3. Flooding

Issue	Council Response
a The crossing at Buttonderry Creek is shown on the plan as a culvert or a bridge. It is noted elsewhere within report documentation that this crossing is a 30 metre clear-span.	- Should a culvert be utilised for this crossing, backwater effects will need to be assessed. - Consent conditions have been recommended which require additional modelling to be undertaken to ensure that such effects will be addressed appropriately.
b An exemption for 25% of each allotment for irrigation purposes is allowable however elsewhere in the applicants documentation it is stated rain tank water is to be included for allowance of irrigation.	Should the rain tank water not be irrigated (as it would be assumed that this 25% would be developed) then this associated tank volume will not be available for future 'airspace' and retention.
c It is noted that storages will be designed in accordance with <i>Ecological Engineering's</i> calculation shown in Table 5.2 and 5.7.	- There is no mention of additional channel retardation forming storage that is required as shown in <i>Ecological Engineering's</i> table 5.10 – Retardation storage Design for WEZ Catchments. - The pro

<i>P.J.</i>	5.06.08	PROJECT NUMBER	DRAWING NO	REVISION
ENGINEERING DESIGNER	DATE	19426	EA01	J

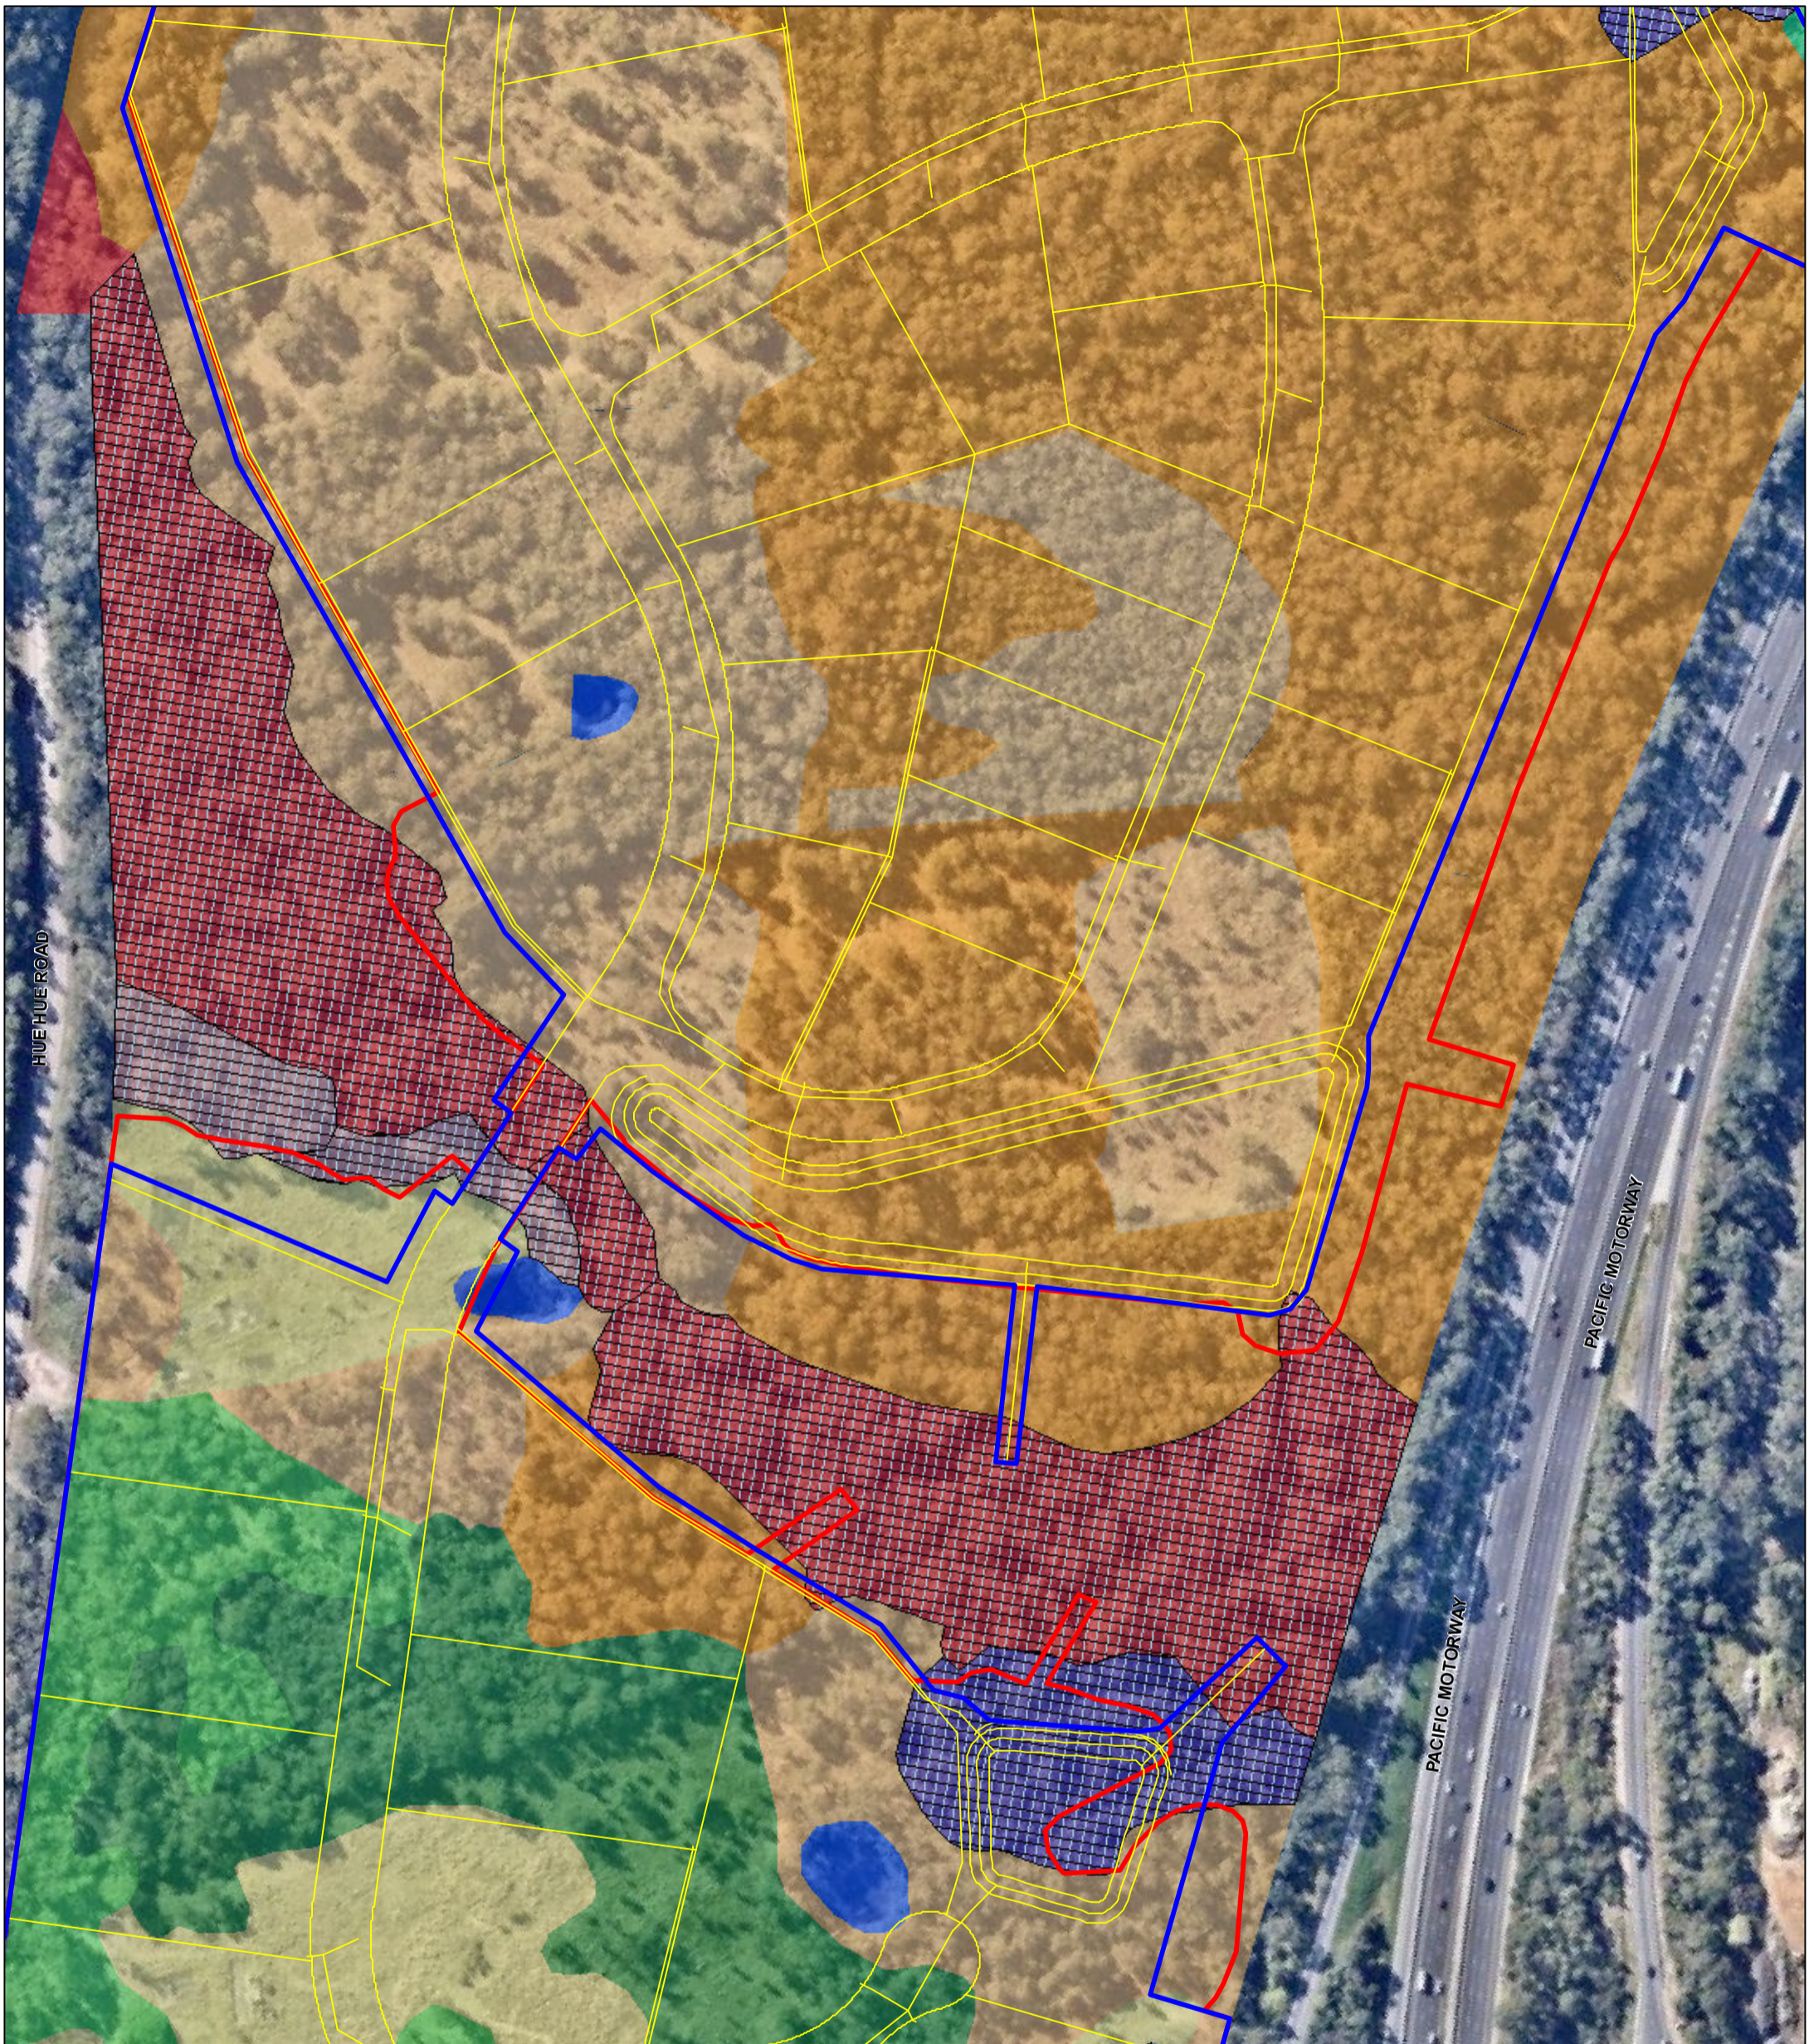
d B2 Stormwater Management	Management of stormwater in B2 channel is deemed to be not appropriate as overland flow is likely to affect proposed Lot 1 and potentially other lots adjacent to the road/overland flow path. The DHI letter (May 2007) indicates that this has been investigated however details of these investigations and outcomes/solutions have not been provided.
e Storage Modelling	The documentation doesn't indicate how flood storage areas have been modelled – inconsistencies exist between the two reports submitted within the documentation.
f Flood reports within the provided documentation are ambiguous and have identified that the 1% AEP has been reduced by 500mm.	- If this level is incorrect, this could pose serious risks to landowners and access to and from the site. - Consent conditions have been recommended which require a revised flood model and analysis of the flood stormwater drainage for the total development site for all watercourses. - It is recommended that the RTA be consulted about the impact of increased flooding behind the F3 – Freeway embankment.
